Building Permit Request for 183 Ribbon Oak Court, Sanford, North Carolina 27332

Requested Actions for Approval:

Revisions to Deck Addition Plans

Revised Plan

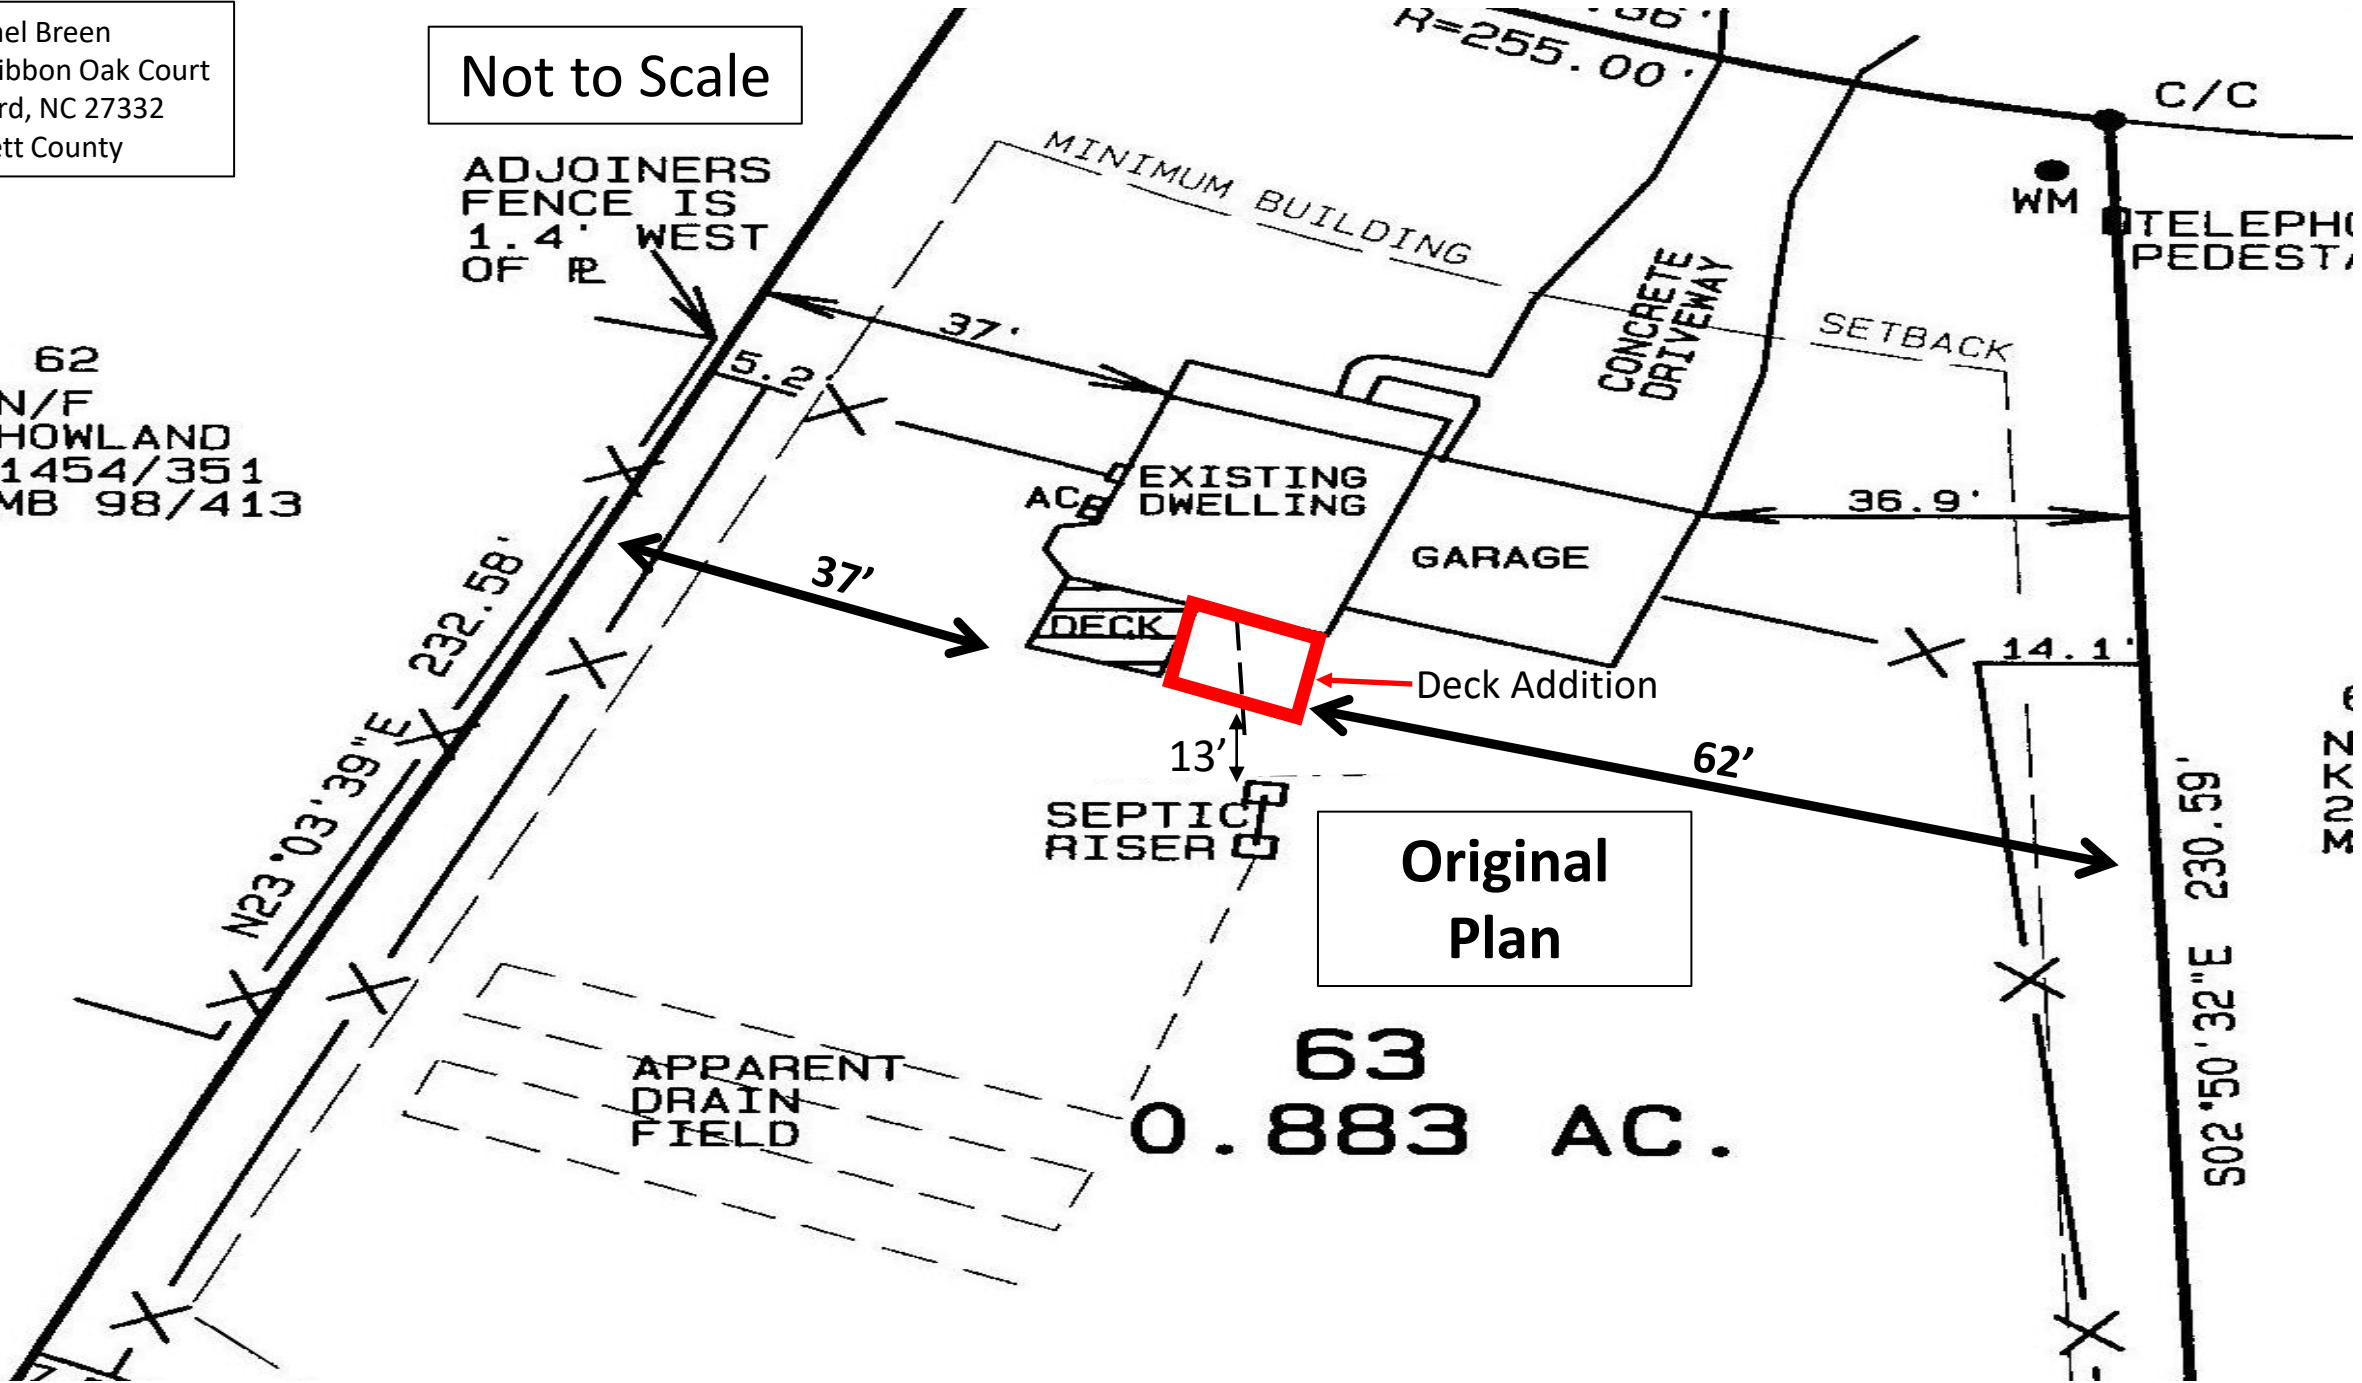
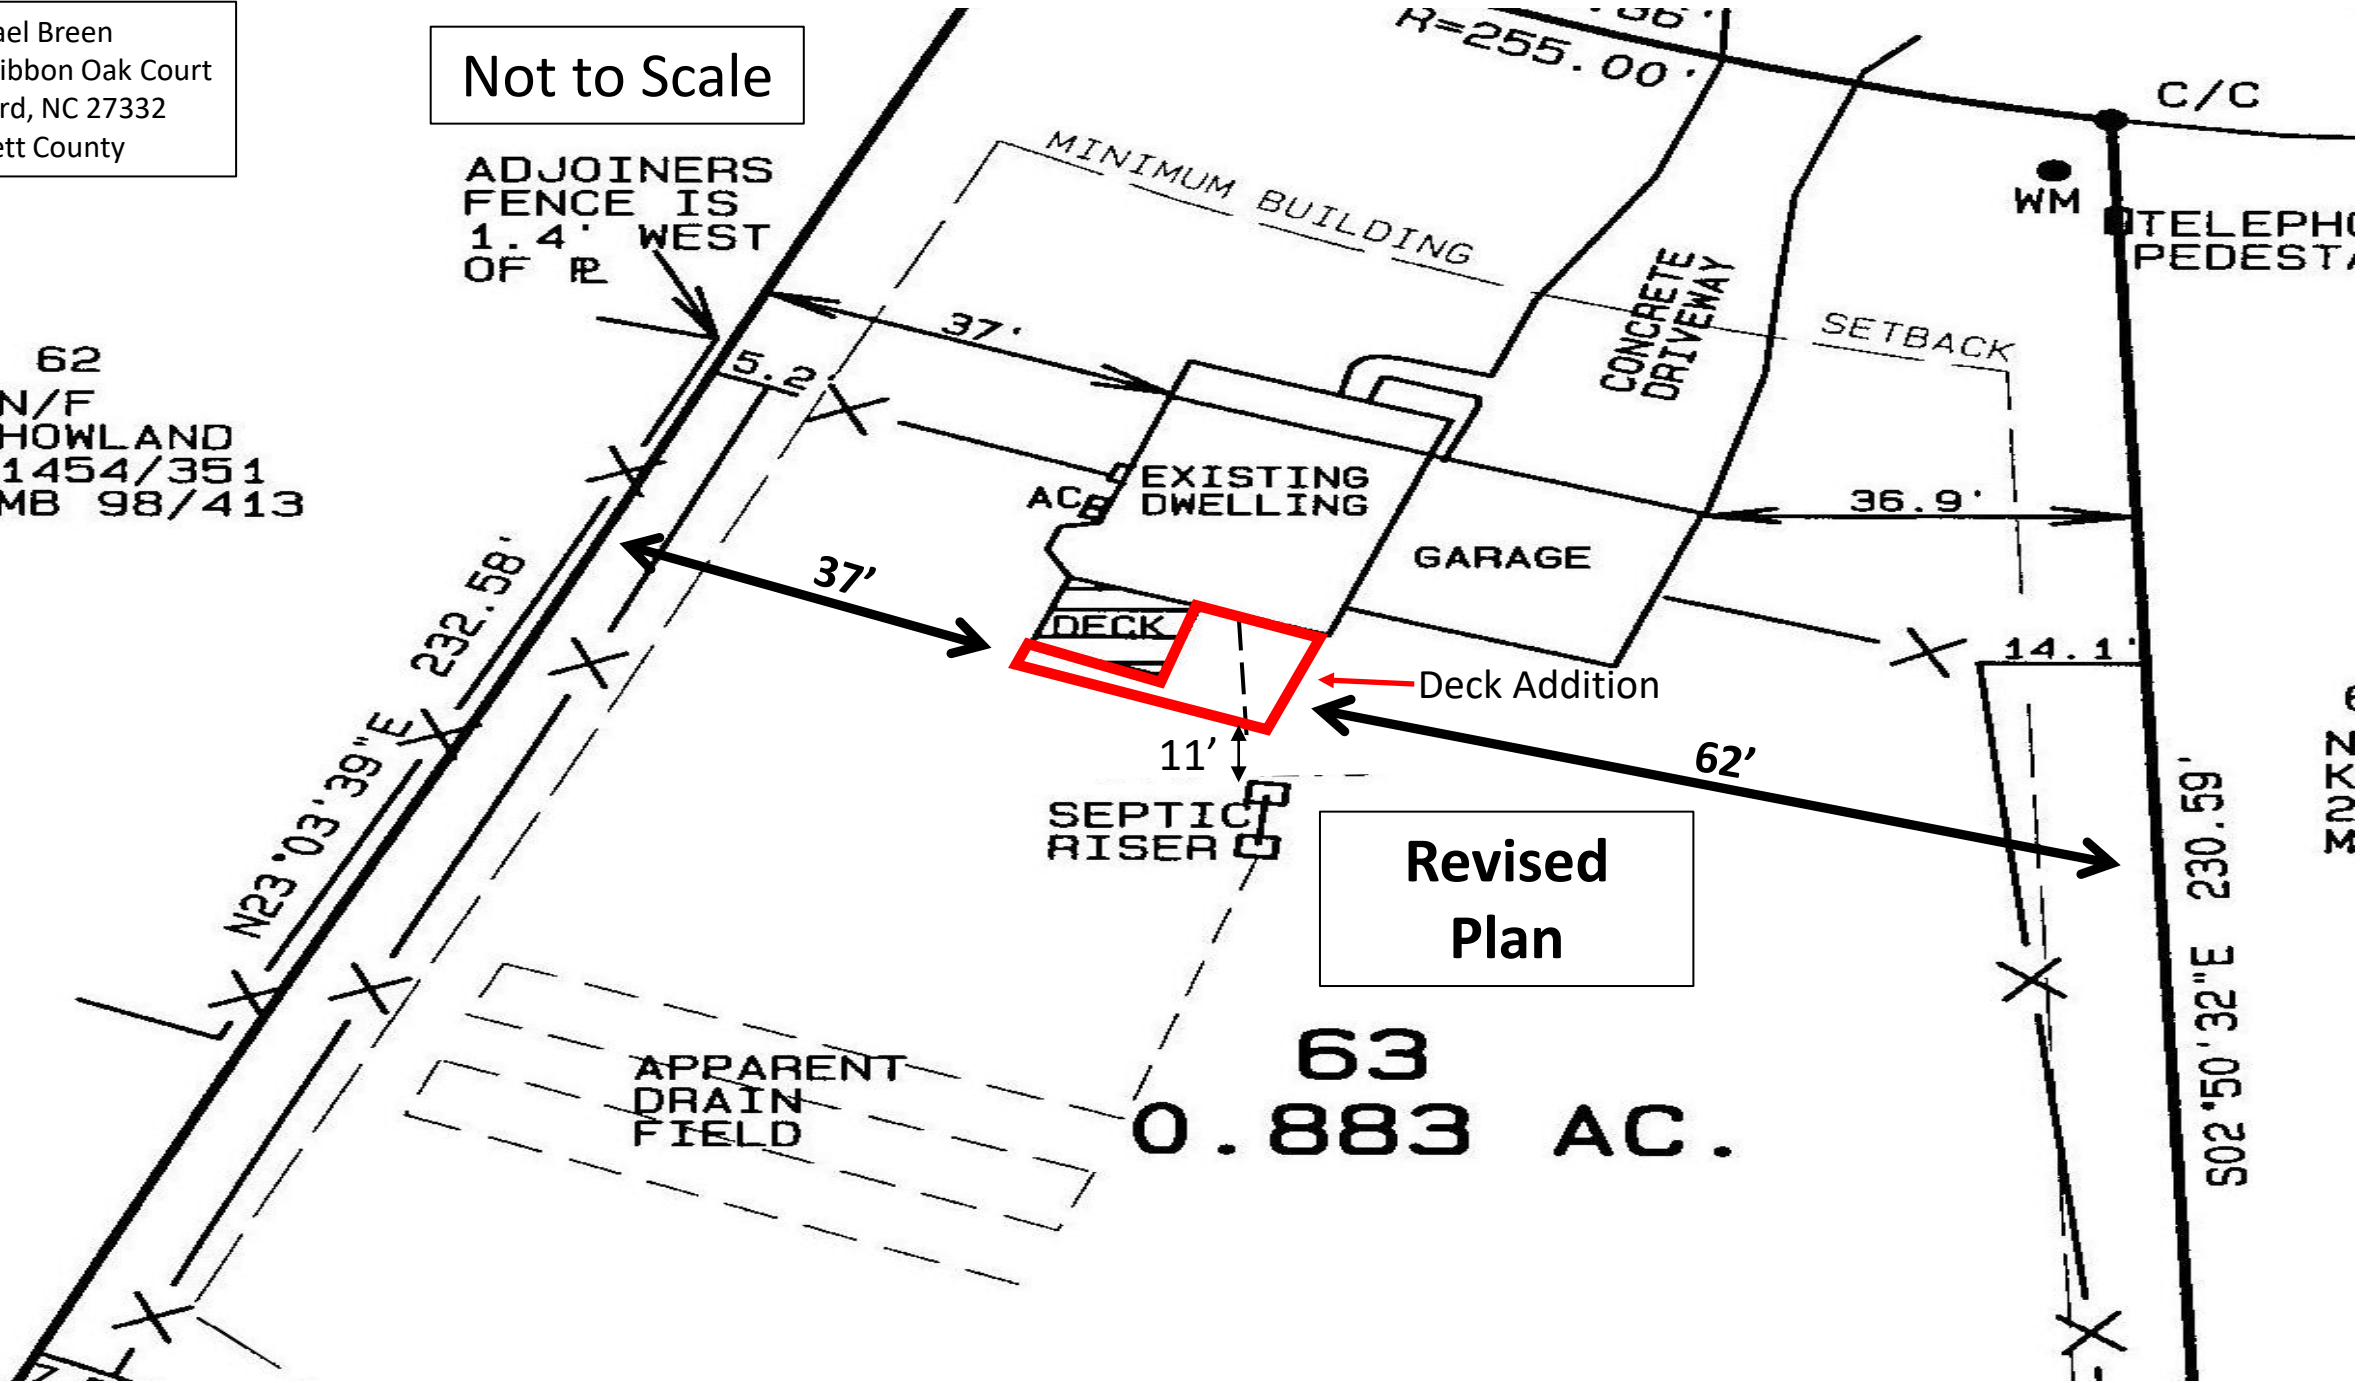
Amendment to Add to Overall Finished Dimension: 2x24' (48 sq/ft).

Planned Overall Finished Dimension: 12x24' (288 sq/ft).
